14, Nightingale Lane

Please find enclosed our
objections to planning application
BN/bb/19/PL.

Proposed Site Masterplan

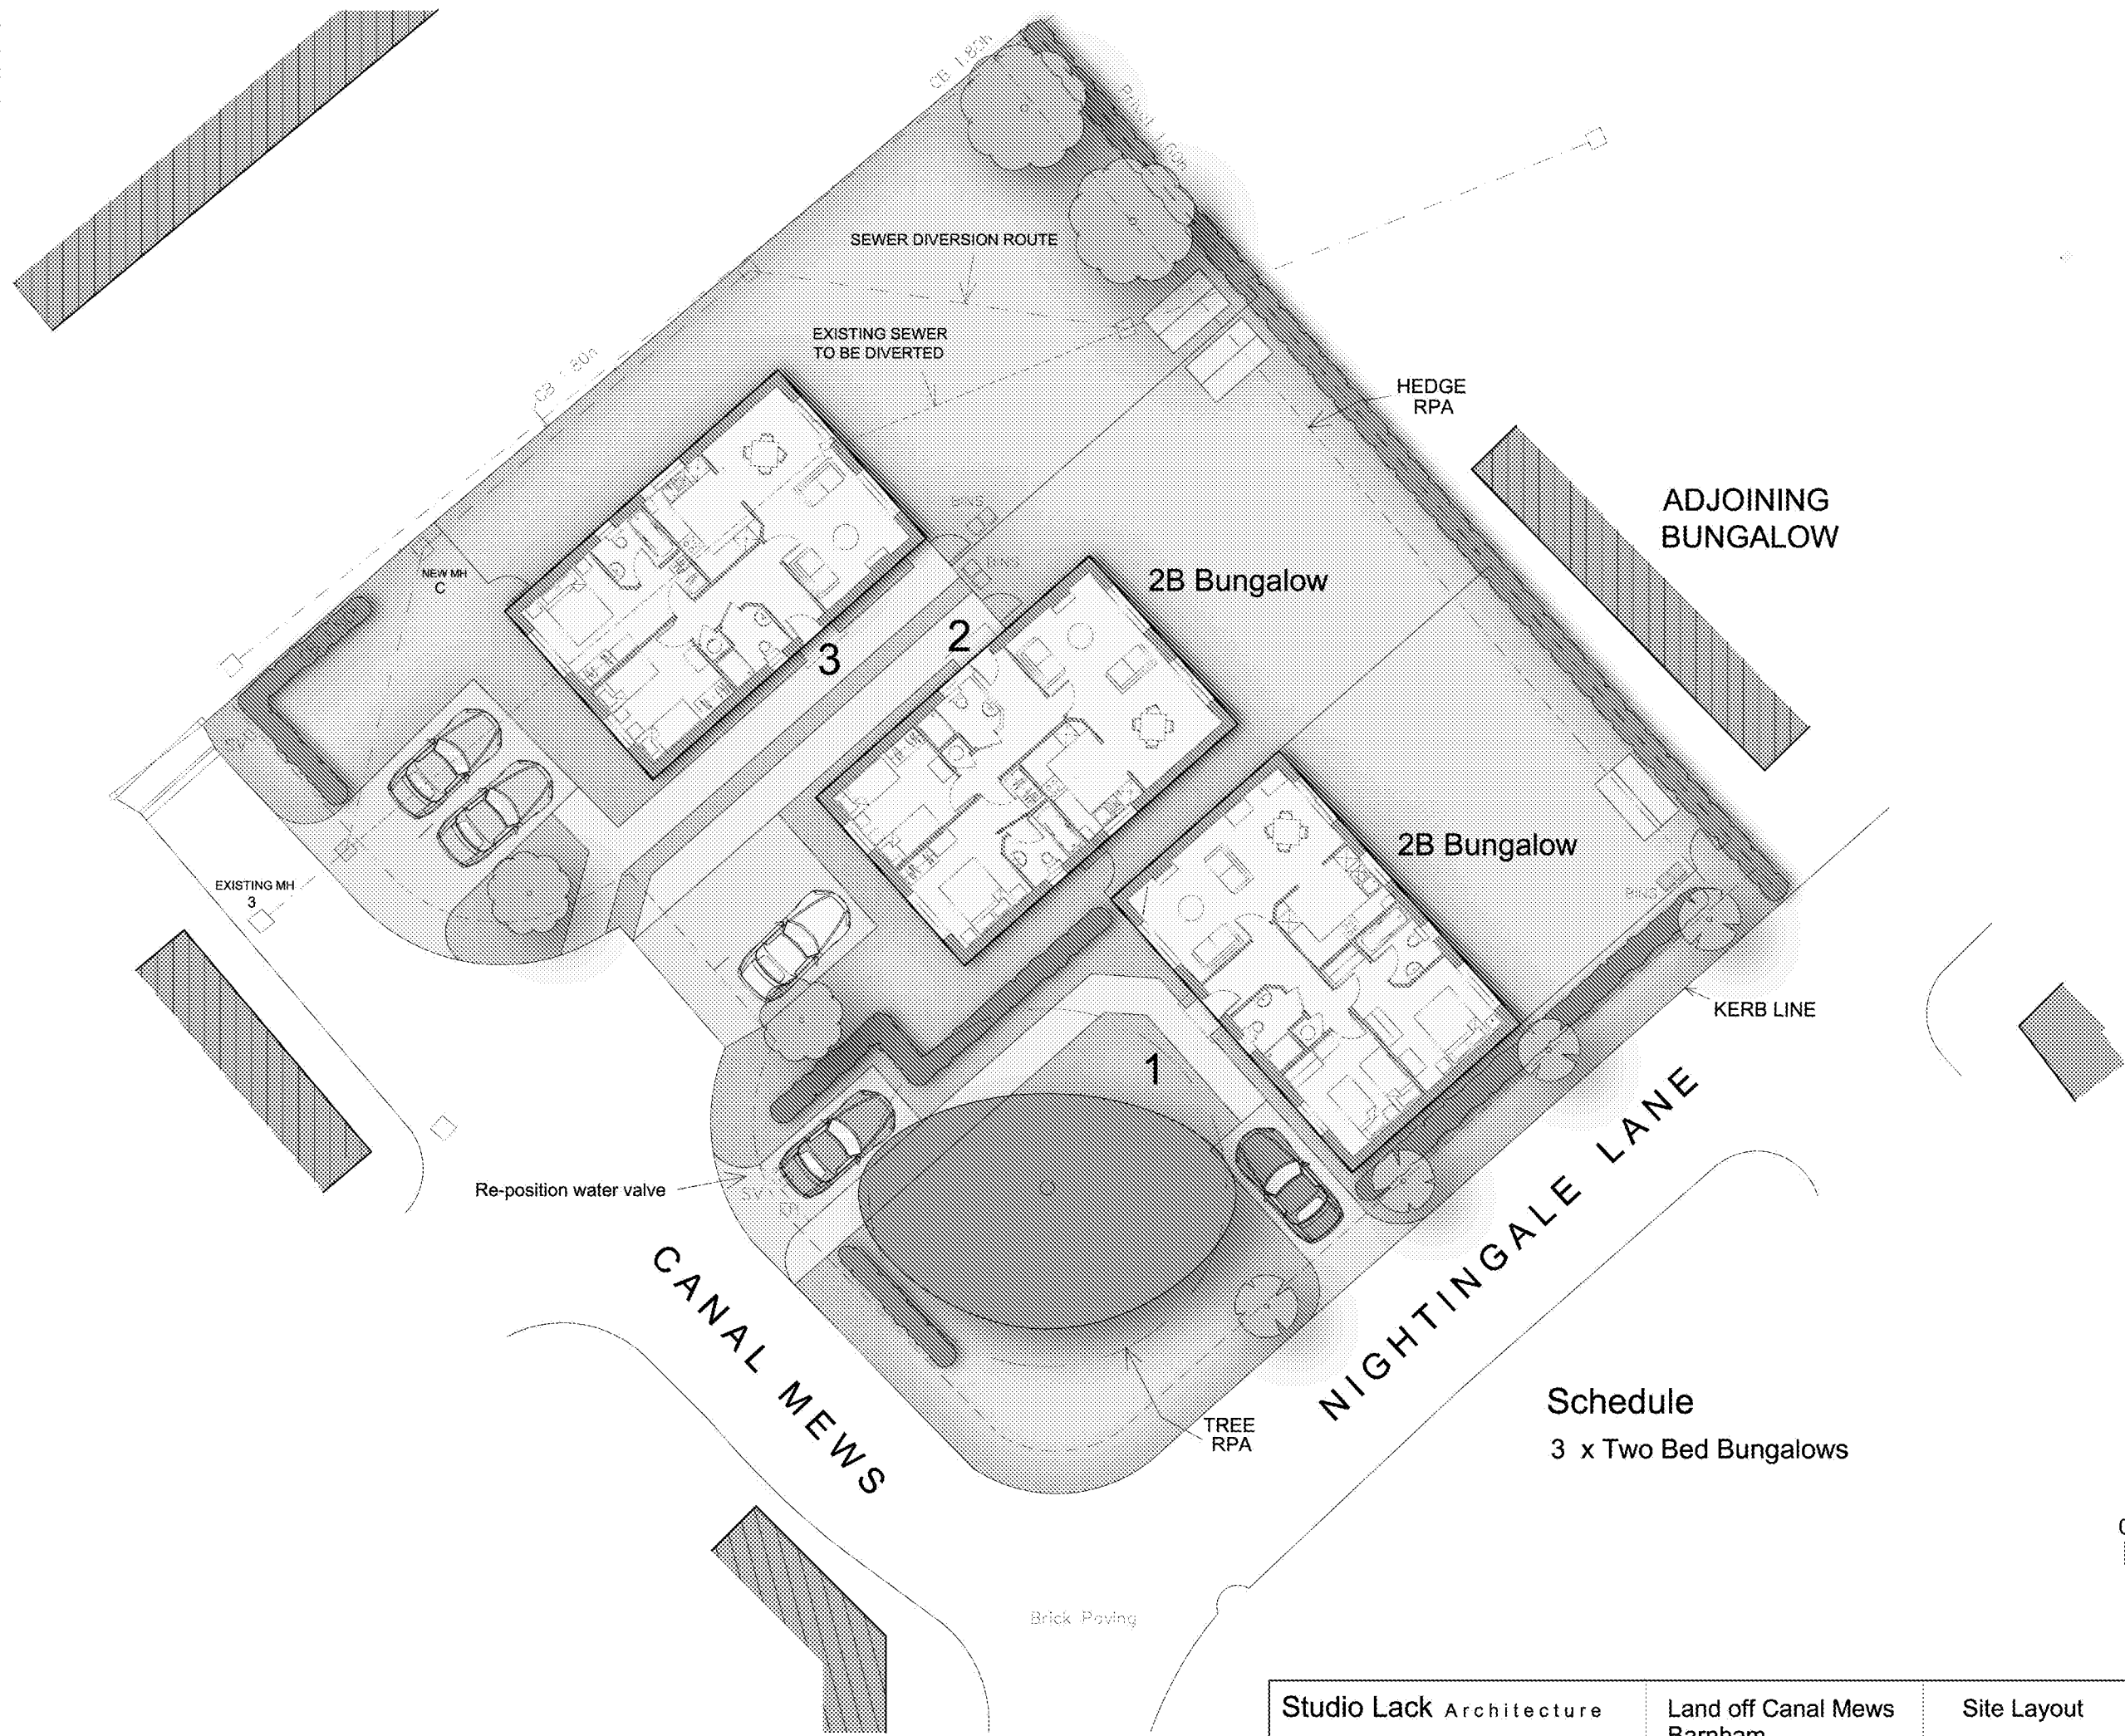
'can' in this section – 'will to be' in Section 3.00? – NB. It has not been possible to locate layout plan 1705-01F.
- Section 6.00, Layout, of 'Planning, Design & Access Statement' states access to be directly off Canal Mews, Arun Place is Private Property.

- • Inadequate parking facilities for the 3 proposed properties and no additional visitors parking provided in an already lacking area for additional vehicle parking, leading to obvious road parking abuse

Drainage Strategy Drawing

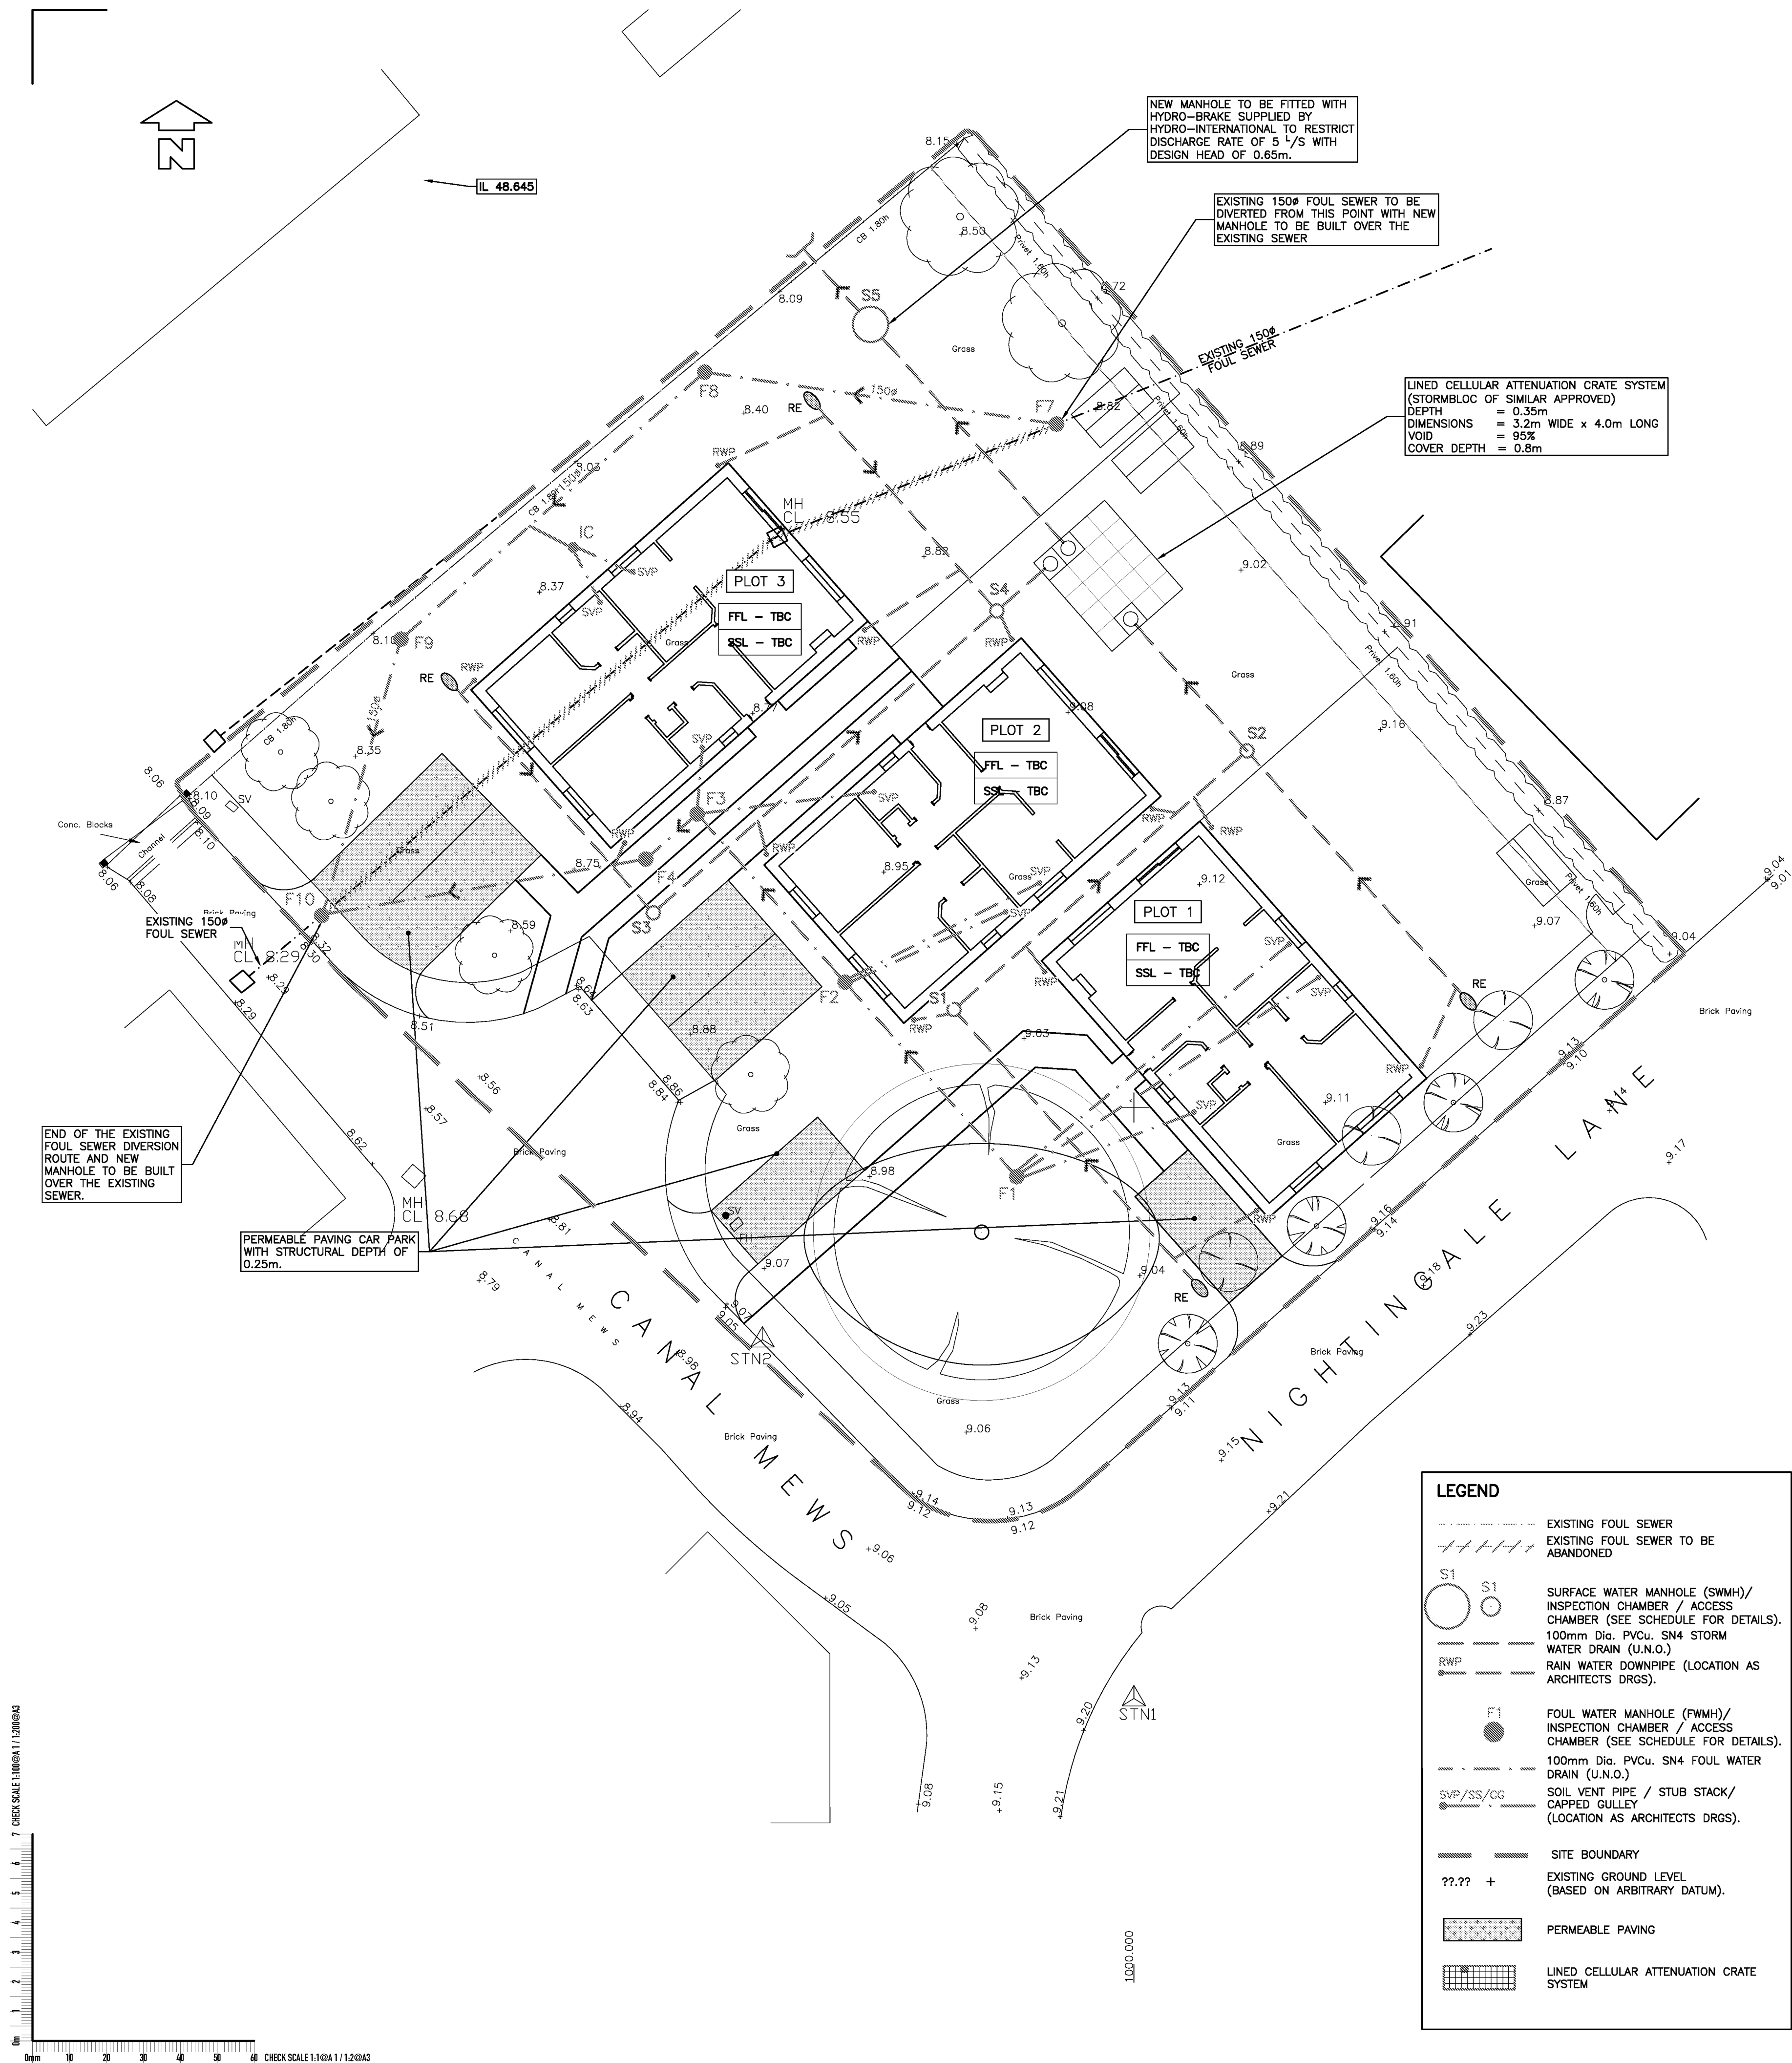
- It is understood the surface water run-off is to be via a culvert to the East of the proposed development – this culvert is in a poor state of repair and concerns are raised regarding its adequacy.

- • If the plan goes ahead this could cause flooding to surrounding areas. The planning application refers to the surface water run off going into the existing Culvert (ditch) that runs along the back of the gardens of Nightingale Lane. This ditch in question fills up in heavy rain and doesn't run away for days. The ditch is even blocked at one end with a plastic cover so the water has nowhere to go. The ditch is never maintained, it is only half the depth that it was when we moved here three years ago and has silted up. Also HML cut the grass which form the sides but don't take the cuttings away. Adding another three bungalows to this culvert will only exacerbate the problem.

- • The proposals also states that the sewers would have to be moved to allow proposal to go ahead. This could cause major problems, residents have experienced blockages already in Nightingale Lane in the past and this needs further investigation. It is unclear if it is a pumped system or gravity fed as if it was gravity fed and the falls were not correct all our properties in Nightingale Lane would block up continually.
